2024/0793

Reserved matters application for residential development of 1no. dwelling with appearance, landscaping, layout, and scale considered at this stage (in connection with outline application 2024/0061)

34 Edderthorpe Lane, Darfield, Barnsley, S73 9AT

NORTH ELEVATION

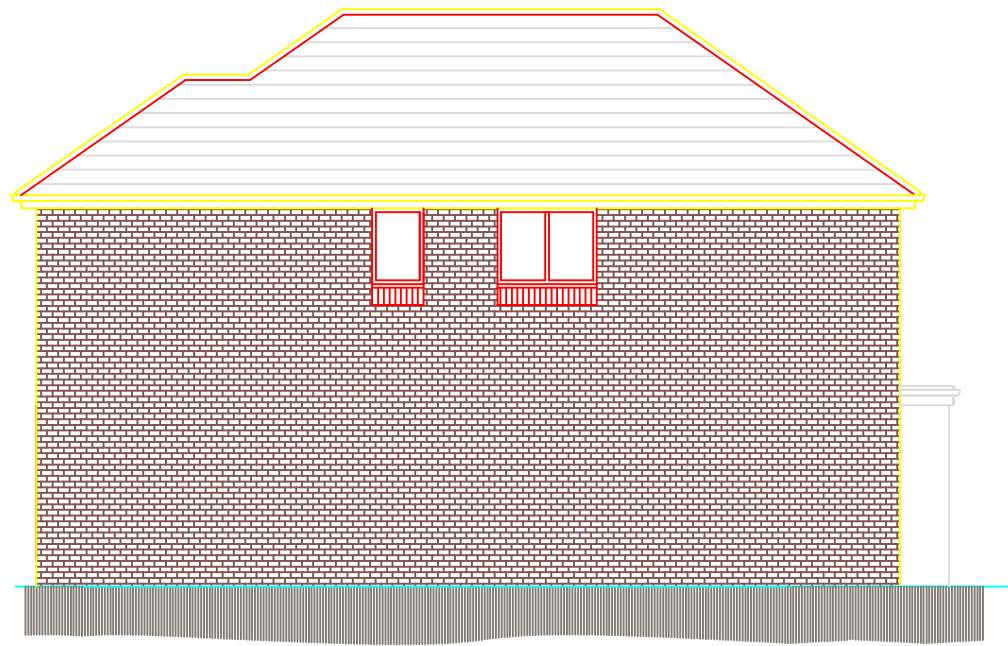
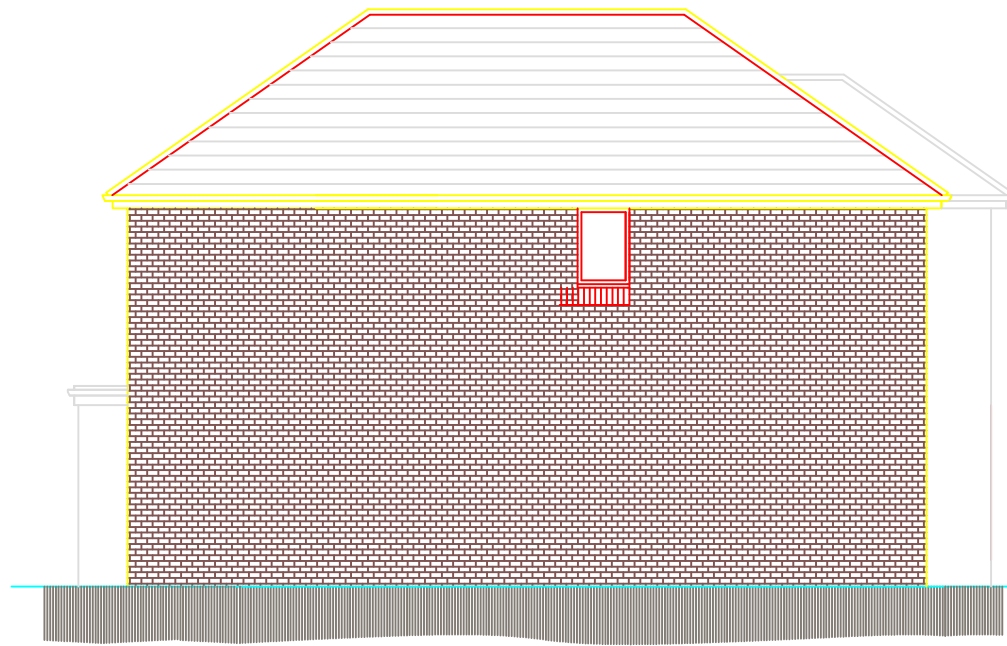
adjacent dwellings. The submitted layout plan shows that the proposal would meet the required separation distances set within the SPD. The principal front and rear elevations show habitable room windows and the side elevations include windows at first floor level, however these are to non habitable rooms, which include a landing, bathroom and ensuite and would therefore not cause any significant overlooking of the adjacent dwellings.

SITE PLAN
SCALE 1:500

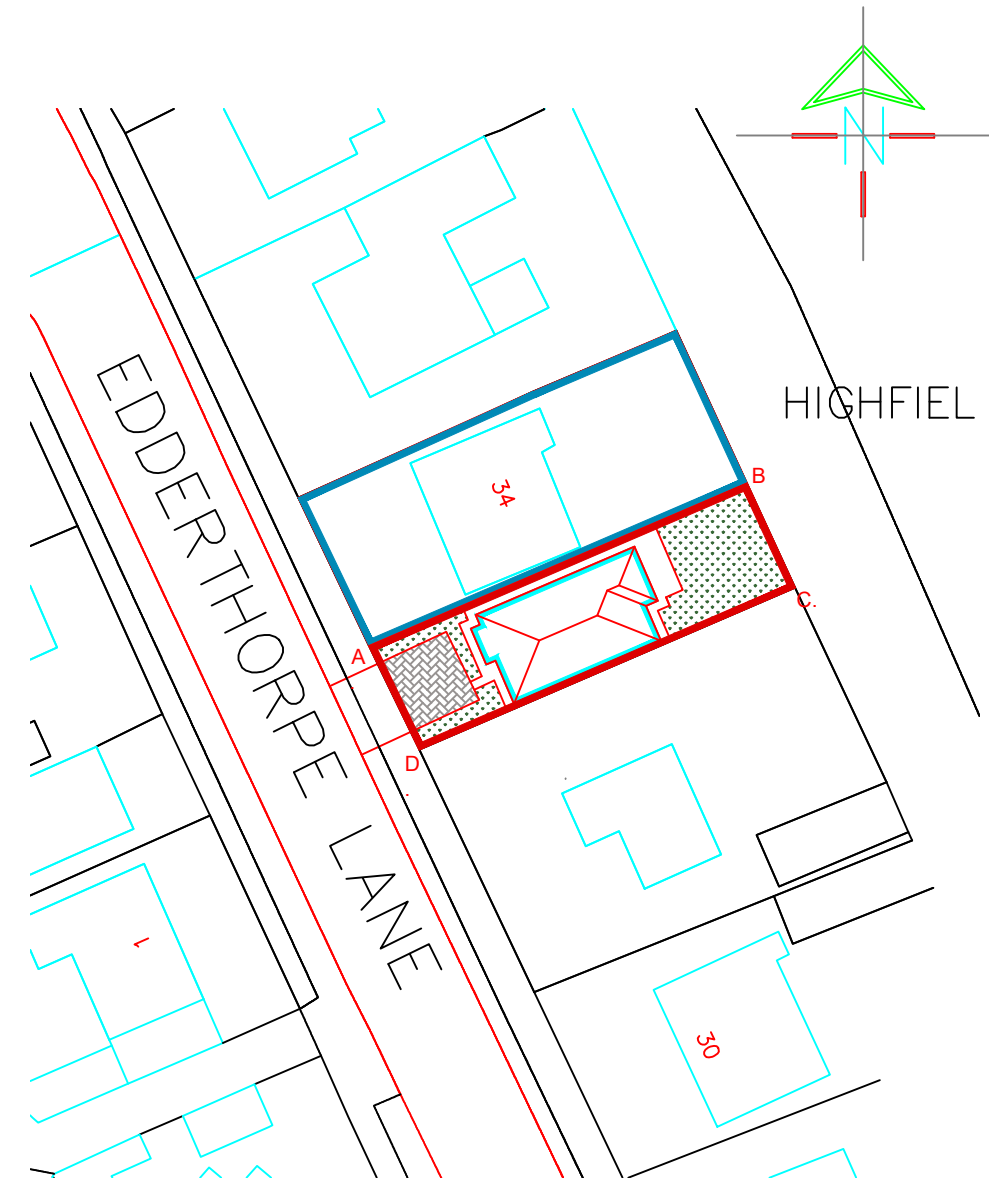
The immediate street scene consists of a mix of semi and detached, two and single storey dwellings. The existing properties along Edderthorpe Lane have front garden areas and parking to the front, or to the side of the dwellings. The site plan shows that the two storey detached dwelling follows the existing building line.

The application is for the reserved matters of appearance, landscaping, layout, and scale associated with application no. 2024/0061. The submitted layout drawing shows a driveway able to accommodate two vehicles. This is commensurate with the council's advice for dwellings of three or more bedrooms. Application no. 2024/0061 showed pedestrian intervisibility of 2m x 2m and that there is ample space to store bins, and it is expected that these elements will remain.

SCREEN FENCE TYPE A
1800MM HIGH AND STEPPED TO SUIT SITE CONTOURS
TIMBER POSTS 125X25MM DARK STAINED TIMBER, FEATHER EDGED

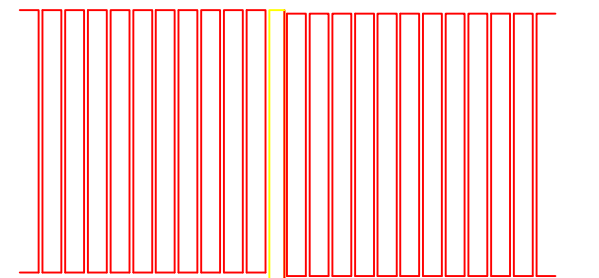
The proposal is for a 4 bed dwelling, with a hipped roof. The principal elevations show habitable room windows and the side elevations include windows at first floor level to a landing, bathroom and ensuite. Screen fencing is also proposed along the boundaries to a height of 1.8m and the existing front brick boundary wall retained and opened up for the proposed access. The proposed site plan shows that a dwelling is sited comfortably on the site without causing any significant overshadowing, overbearing, loss of light or overlooking impact.
